**Addendum No. 2**

RE: Contract # C203905

**Cleveland County (R-2707C)**

US-74 (Shelby Bypass) From East Of NC-226 To East Of NC-150

Drawing file: 400 Structure Plans - Bridges / 407_005_R2707C_SMU_GD03_S7-3.pdf

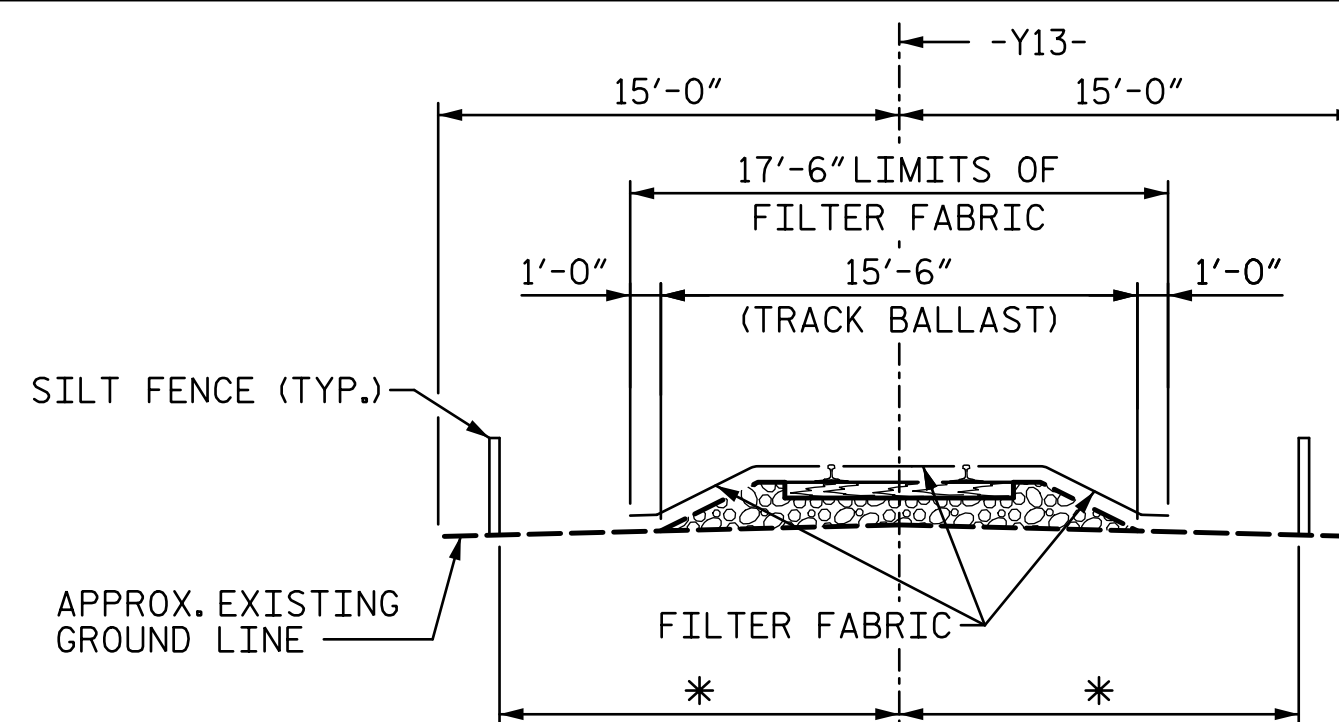
<b>Sheet No.</b>	<b>Revisions</b>
S7-3 and S8-3	Added a column to the Bill Of Material for "Foundation Excavation" on both sheets
